STIP No. A-0009CC

Concurrence Point 4B, Hydraulic Design Review Meeting Minutes

Purpose: The purpose of the meeting was to review and discuss the 30% drainage plans for STIP A-0009CC. The limits of the A-0009 CC Section are NC 143 from 0.5 miles north of the Appalachian Trail to NC 28 and NC 28 from NC 143 to 0.2 miles west of SR 1235 (Gunters Gap Road) for a length of approximately 4.0 miles.

PROJECT REFERENCE NO. A-0009CC	SHEET NO. 38
R/W SHEET NO.	HYDRAULICS ENGINEER
INCOMPLETE PLANS DO NOT USE FOR A/W ACQUISITION	
DOCUMENT NOT CONSIDERED FINAL UNLESS ALL SIGNATURES COMPLETED	
 TGS ENGINEERS 804-C N. LAFAYETTE ST SHELBY, NC 28150 PH (704) 476-0003 CORP. LICENSE NO.: C-0275

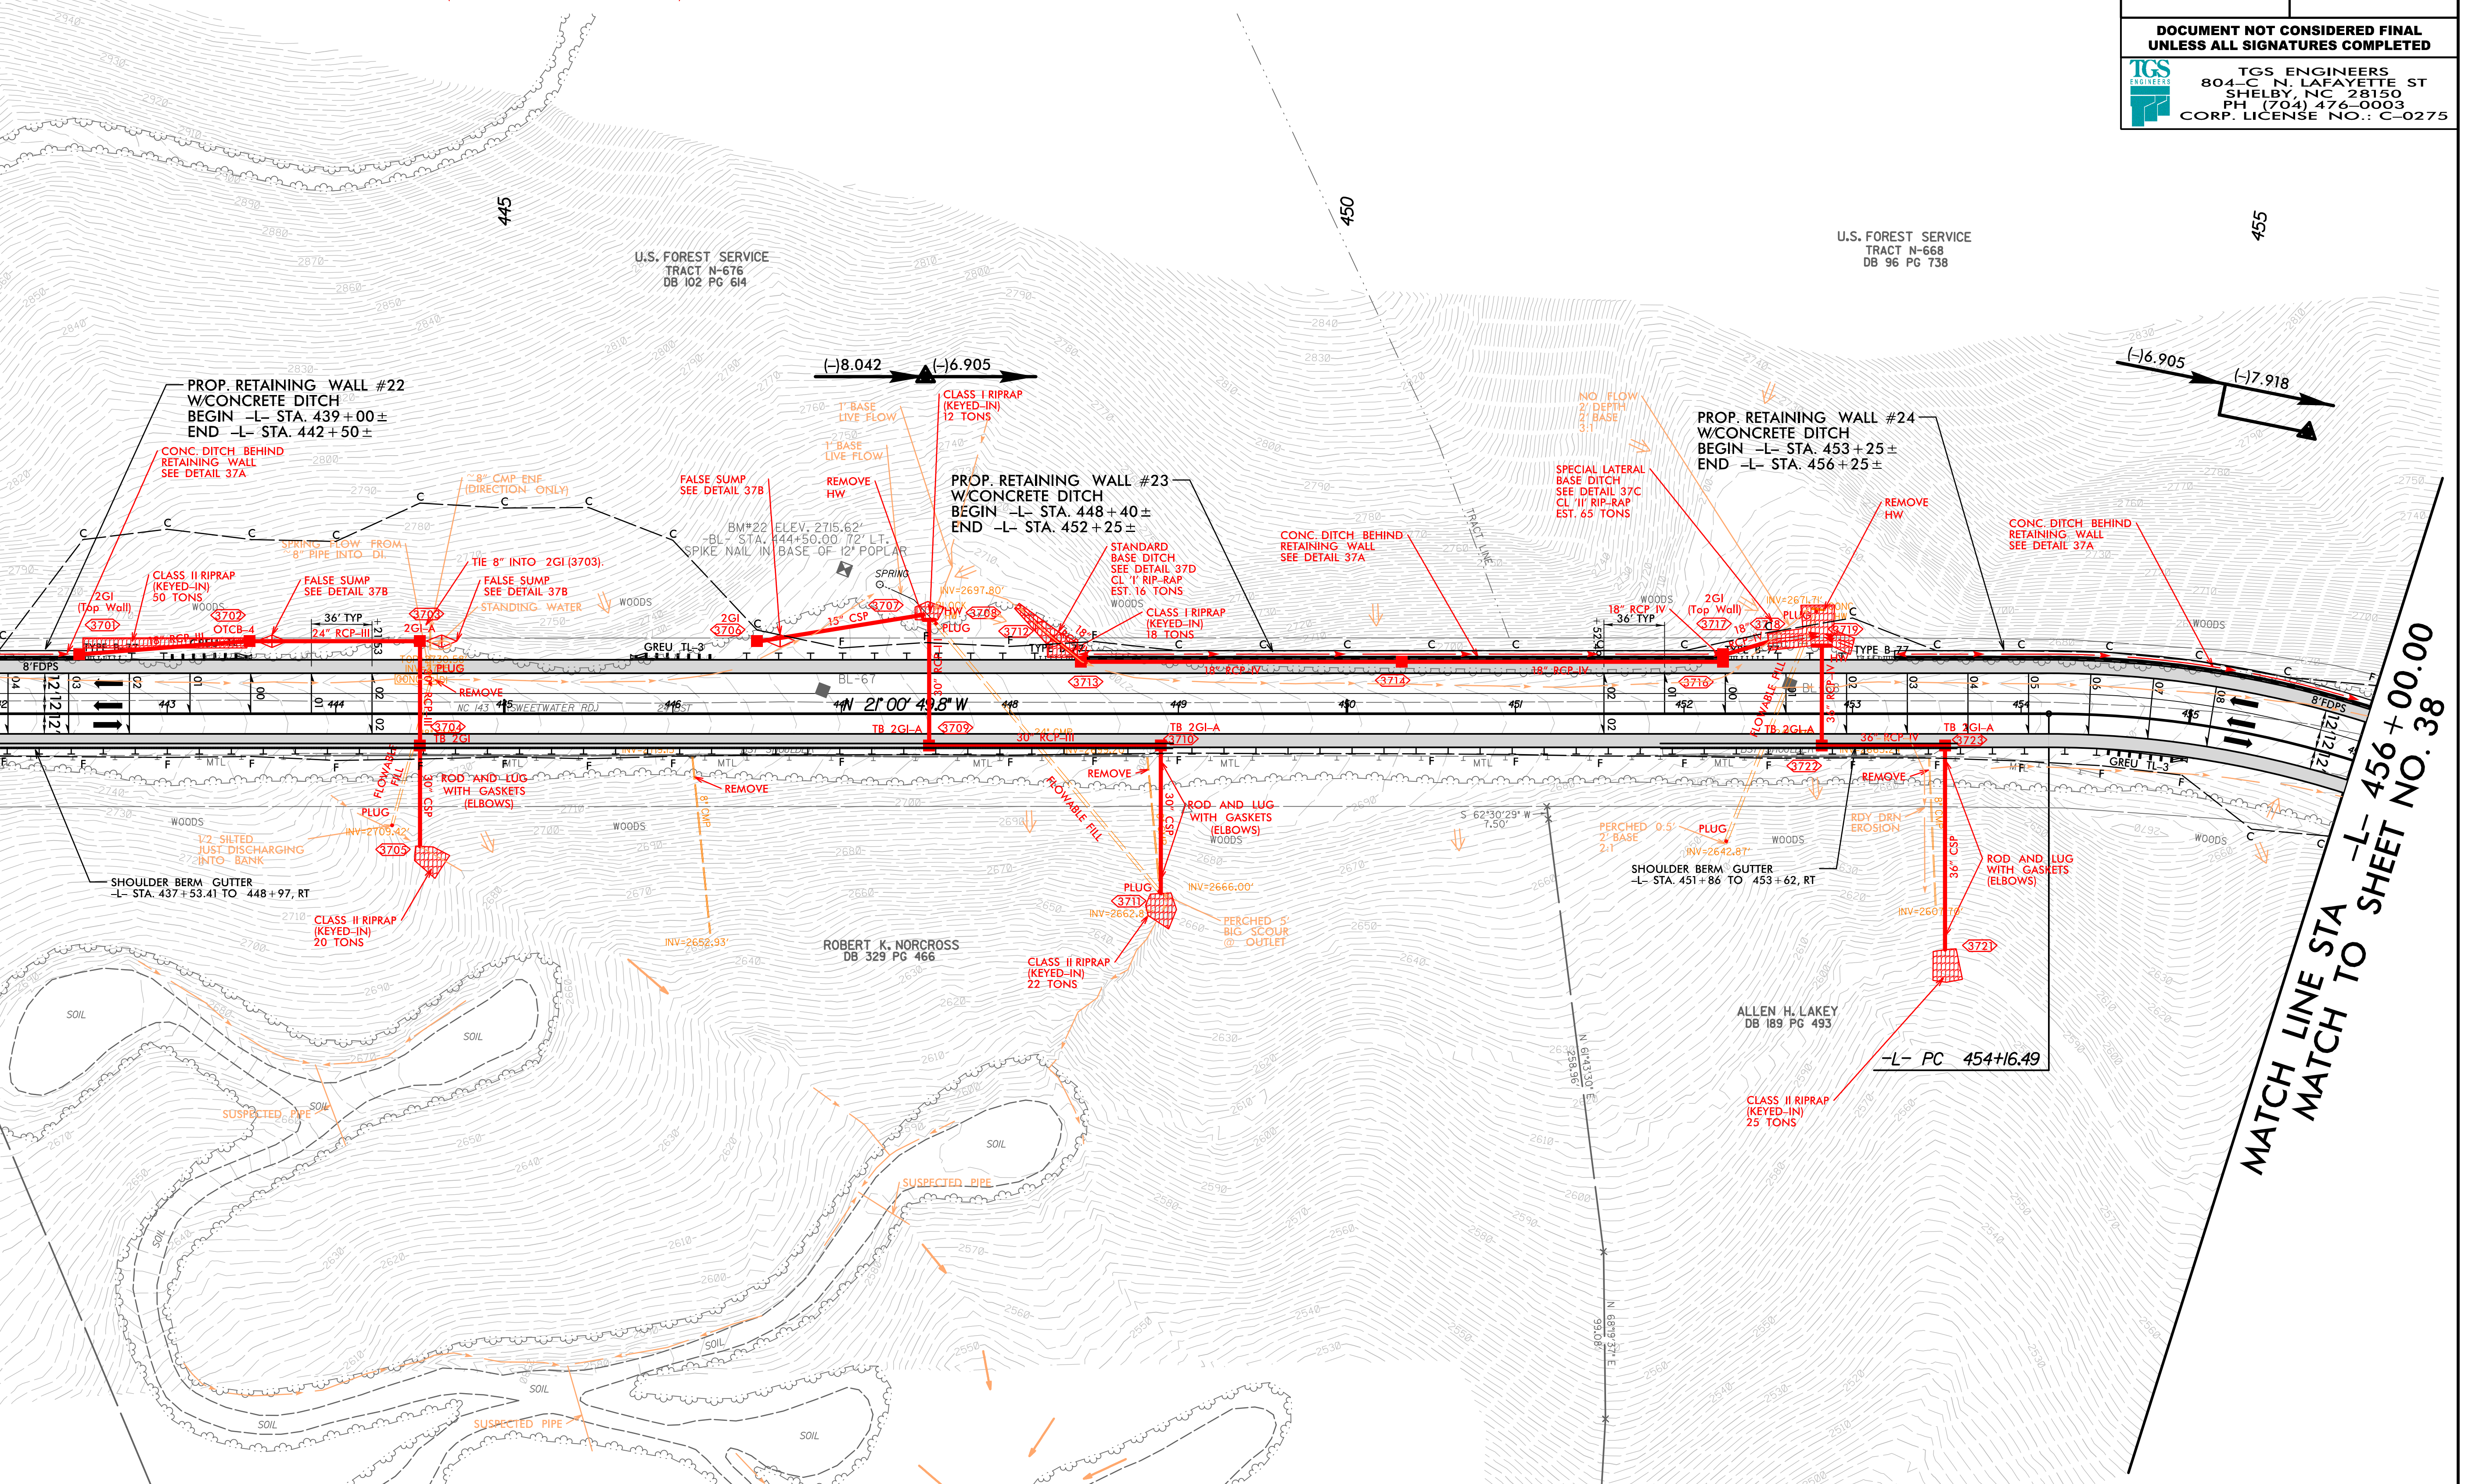
Stream "SBC" (C), perennial, on -L- at Station 458+25 LT & RT

- Stream flows to Carver Branch. Stream is approximately 3-feet wide on a 35-55% slope. The existing 36-inch CMP on 17% slope will be relined. The 36-inch CMP outlet is perched 5-feet.
- The existing CMP will be replaced with a 36-inch CSP on a 4.7% slope at downstream end. The pipe will not be buried due to steep slope. Class I Rip-Rap will be utilized for outlet channel stabilization.
 - USACE asked if the outlet will be perched
 - TGS responded no, the outlet will be at-grade
 - NCWRC inquired about the relining process and how it works
 - TGS responded that it is a sleeve, and a spray-on resin will be used to adhere the sleeve to the existing pipe. Relining will reduce the diameter of the pipe by approximately 1-inch

MATCH LINE STA 470+00.00
 MATCH TO SHEET NO. 39

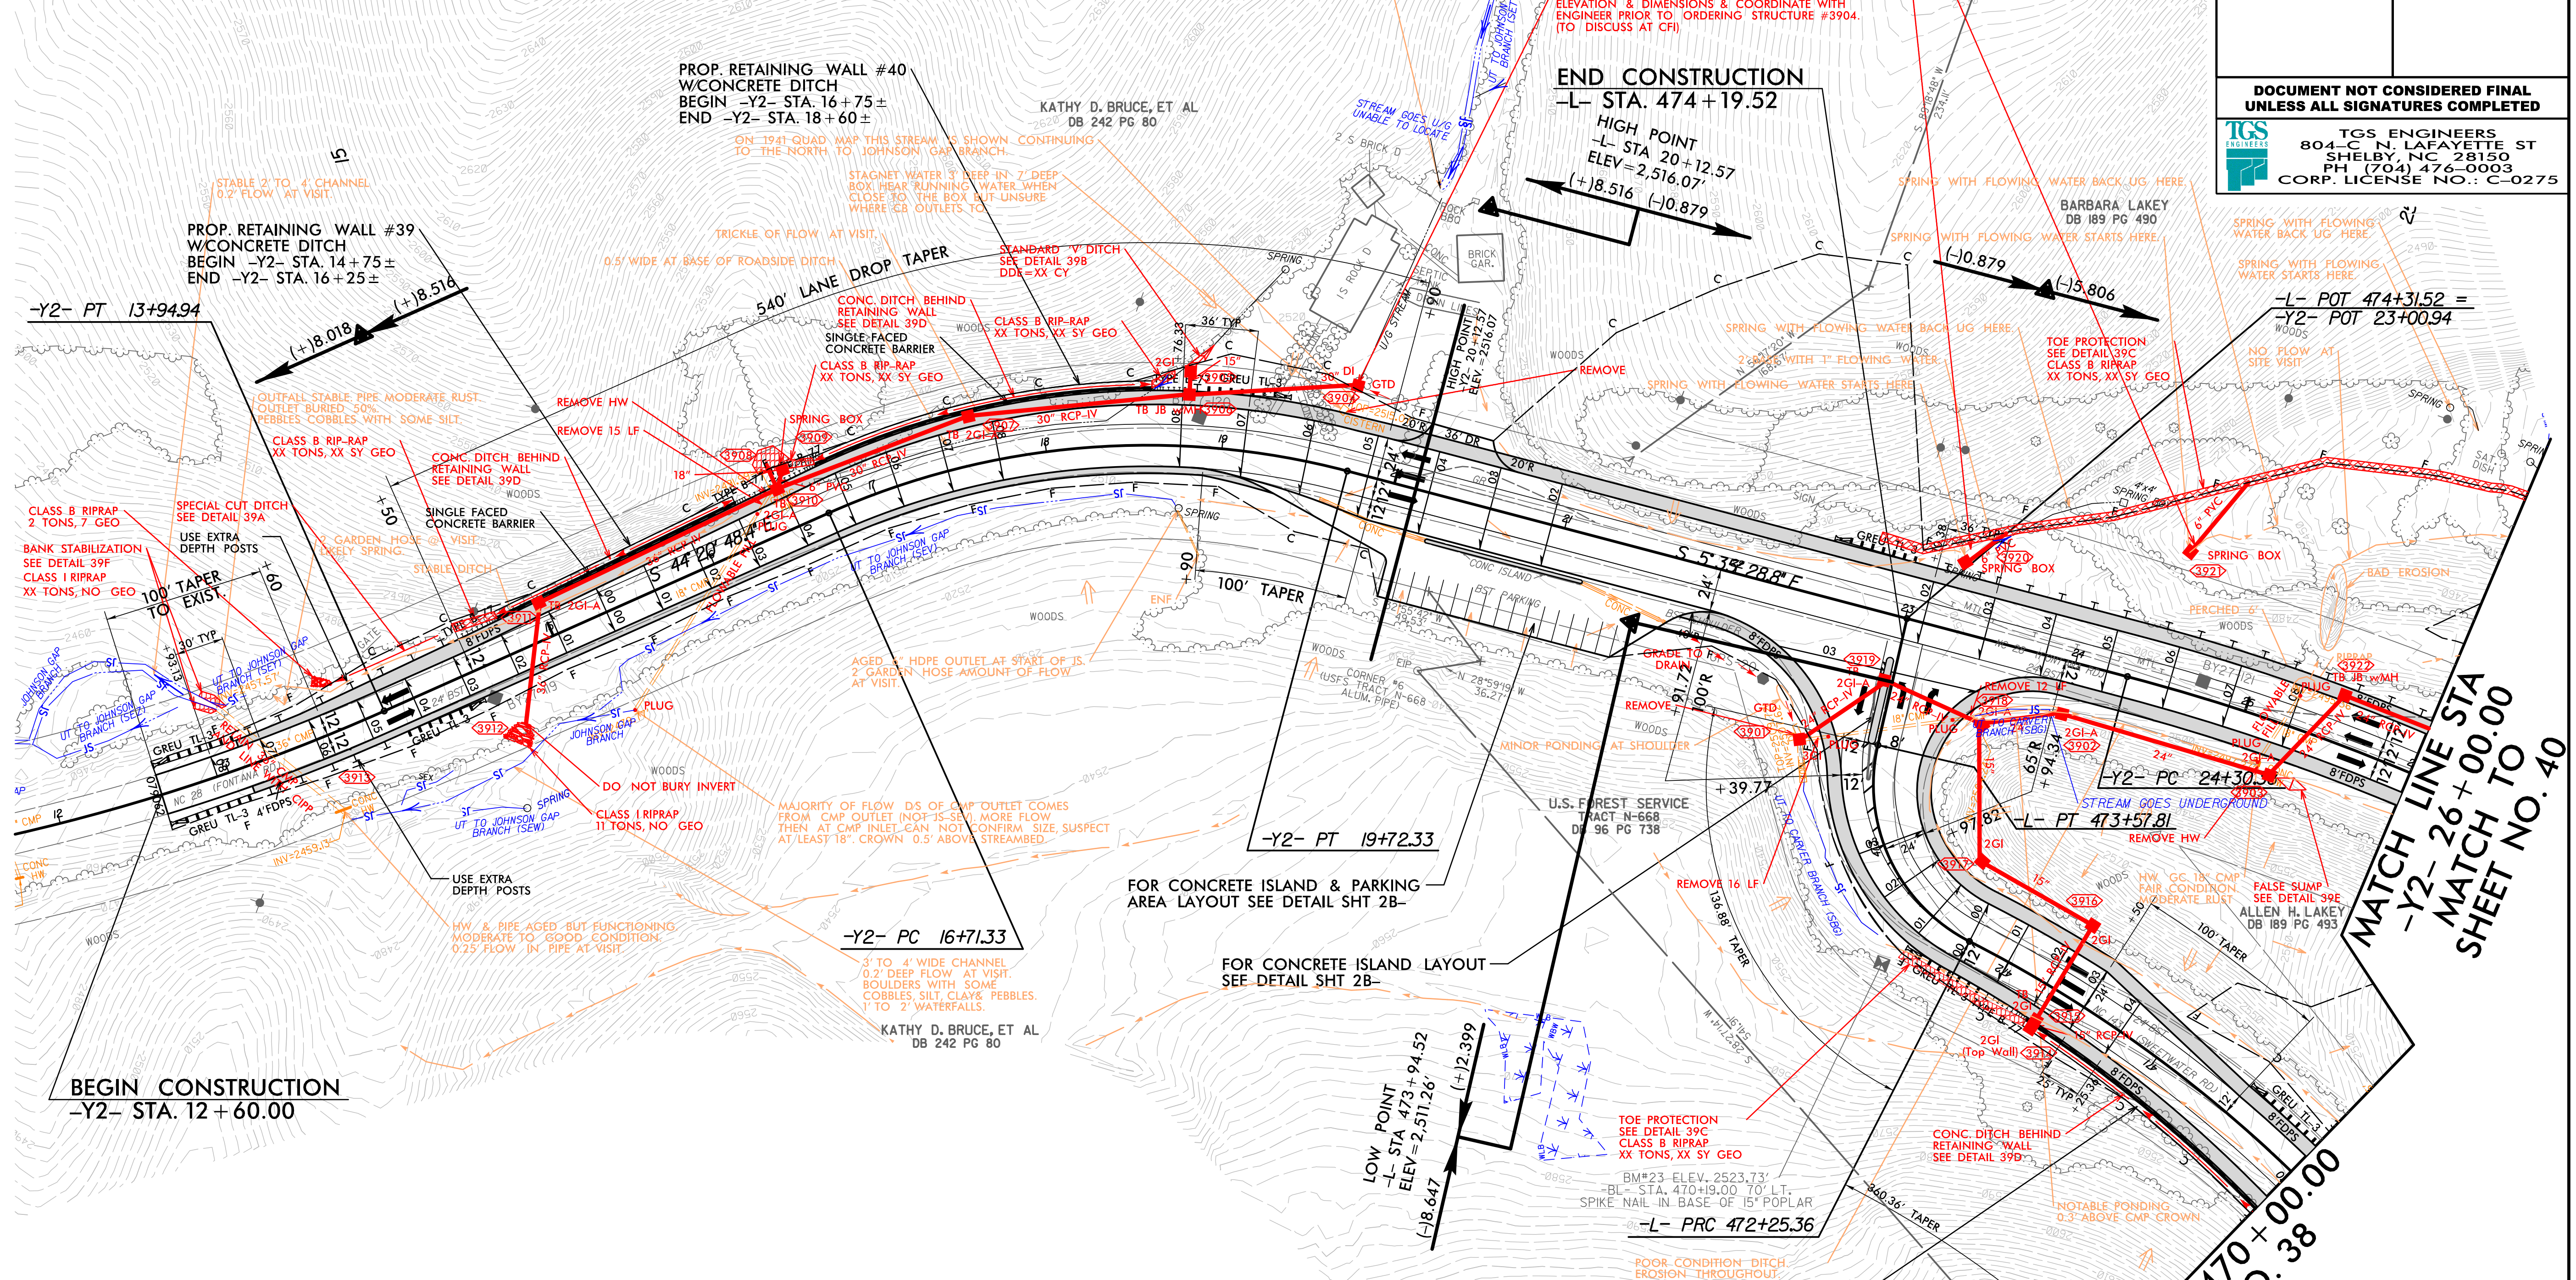
Stream "SBG" (C), intermittent, on -L- (NC 143) Station 472+50 LT to Station 474+00 RT

- Stream is approximately 1-foot wide on a 6-14% slope. The existing system which flows to Carver Branch will be replaced with a proposed 24-inch system on a 0.5-5.1% slope.
- Minimal impacts to the left of -L- and unavoidable loss to the right of -L- due to proposed roadway improvements
- Stream goes underground at Structure 3902

Johnson Gap Branch (C), perennial, on -Y2- (NC 28) at Station 13+30

- Stream is approximately 3- to 4-feet wide on a 10% slope upstream and 6% downstream. The existing 36-inch CMP will be retained and relined with Cured in Place Pipe (CIPP) at a 1.7% slope. Class I Rip-Rap will be utilized to stabilize banks at the outlet.
- NCWRC asked if there was any treatment for water that goes in the concrete ditches behind the retaining walls
 - TGS stated that the project was topographically constrained. It was explained that concrete ditches intercept clean water from offsite drainage which is primarily from forested areas
 - NCWRC encouraged Team to get as much treatment as possible

PIPE HYDRAULIC DATA
*4017-Y2- Sta. 36+01

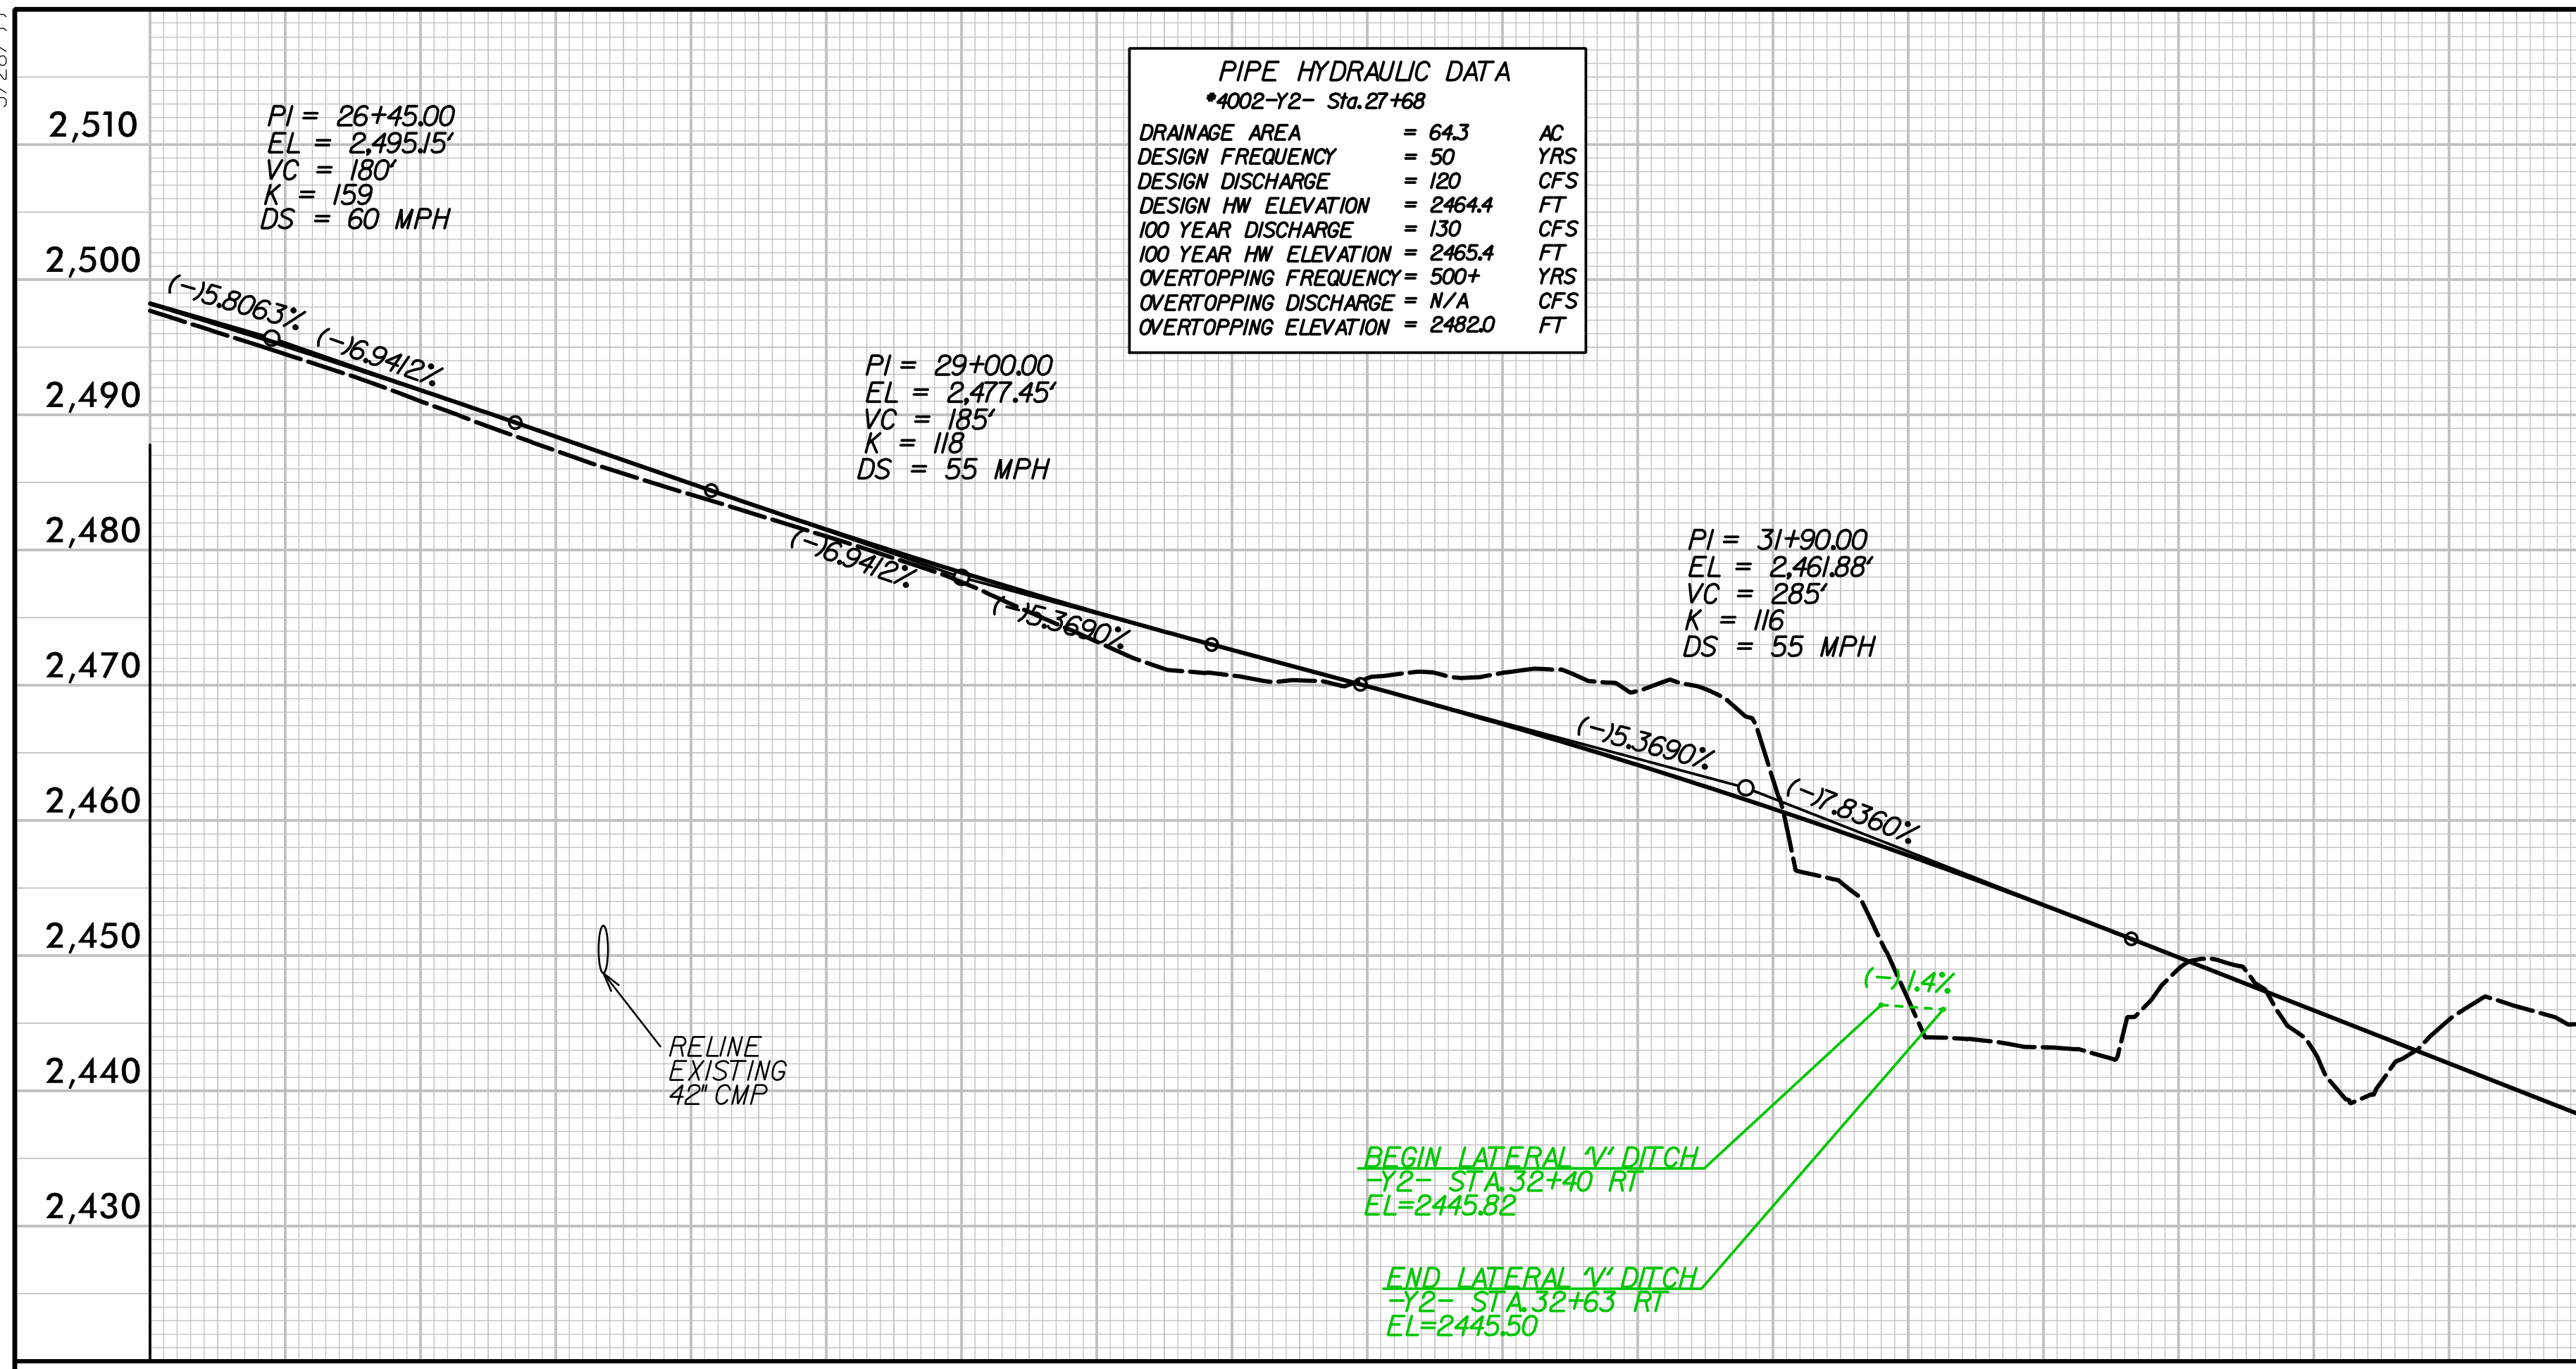
Stream "SBC" (C), perennial, on -Y2- at Station 36+00 LT & RT

- Stream which flows to Carver Branch is approximately 4-feet wide on a 20-30% slope upstream and 2.5- to 6-feet wide on an 8% slope downstream. The existing 42-inch CMP on a 15% slope with an outlet perched 7.5-feet will be replaced a proposed 48-inch system on a 1-45% slope.
- The proposed system removes the 7.5-foot perched outlet. The outlets will be on a 1% grade to minimize outlet velocity. Class I Rip-Rap will be utilized for outlet protection.
 - NCWRC asked if we were assuming there would never be fish passage, so the velocity is being reduced for erosion purposes
 - TGS confirmed and stated that fish passage is not feasible in this location
